Online Comment

Application H23-0508-24
Location Adj Holmlea Millgate Whaplode PE12 6RT
Proposal Proposed demolition of existing dutch barn, change of use of land to domestic curtilage and erection of single storey timber lodge with associated off street parking and landscaping

Name Historic Environment Officer
Address Lincolnshire County Council Lancaster House 36 Orchard Street LN1 1XX

Drawing Title:
EXISTING DUCH BARN TO BE DEMONISHED.

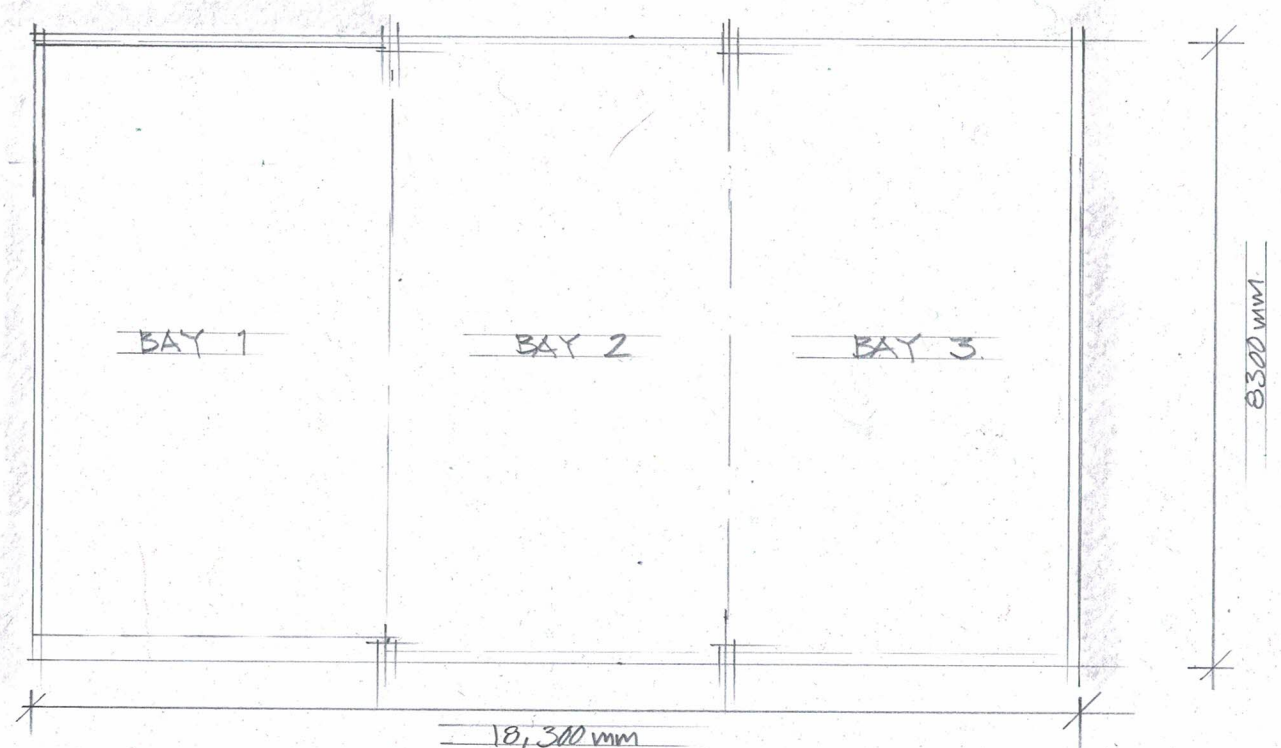
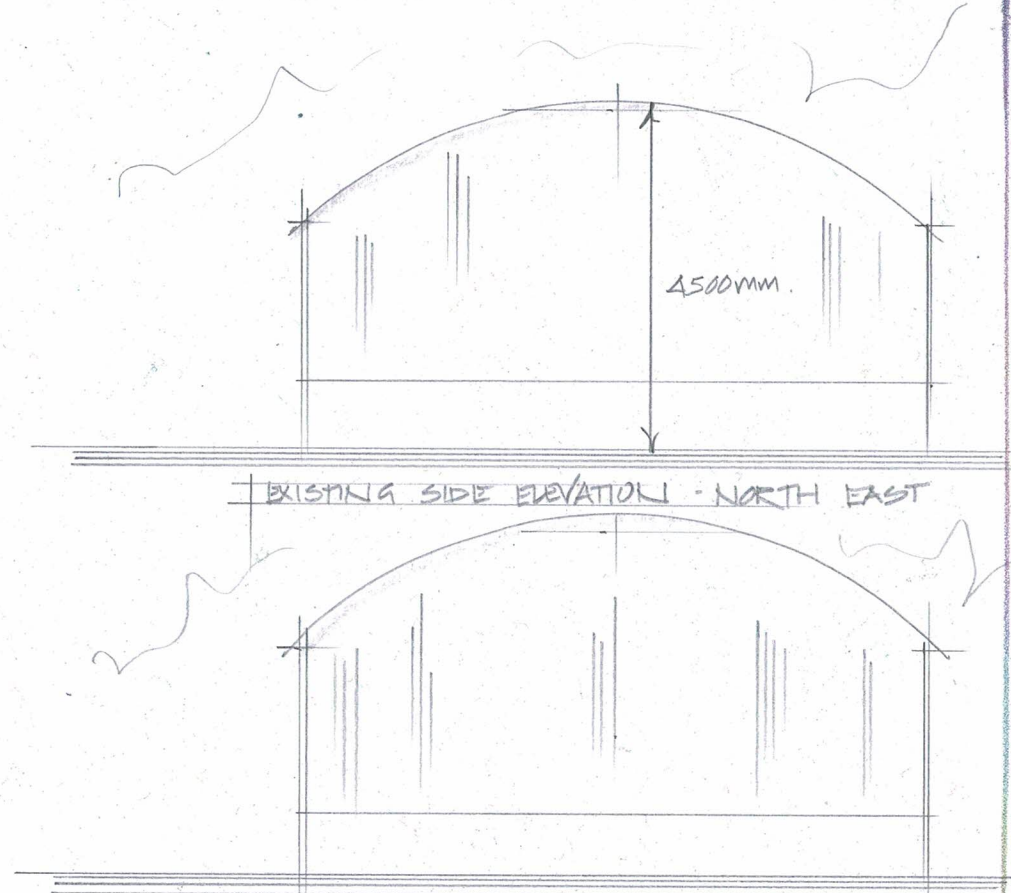
These types of construction are highly distinctive buildings. The Dutch barn precise date and condition is not currently established. Any documented pre-1880s examples will be rare. 1880-1940 Dutch Barns are included in Historic England, Agricultural Buildings, Listing Selection Guide, April 2011.

Demolition will have a significant impact on any surviving original fabric of the barn.

Currently there is insufficient specific information on the heritage significance for the site and the extent of impact to the standing building s from the proposed development.

Given the unknown date and condition, and potential significance, I recommend that the applicant submit the results of a level 1 historic building recording of the barn, in accordance with Historic England's document 'Understanding Historic Buildings: A Guide to Good Recording Practice'. This will enable any remaining original fabric of the barn which currently survives on this site to be initially assessed and recorded. This will also help inform an appropriate mitigation strategy for the proposed impact if necessary (ie: a higher level of historic building recording and should permission be subsequently granted.
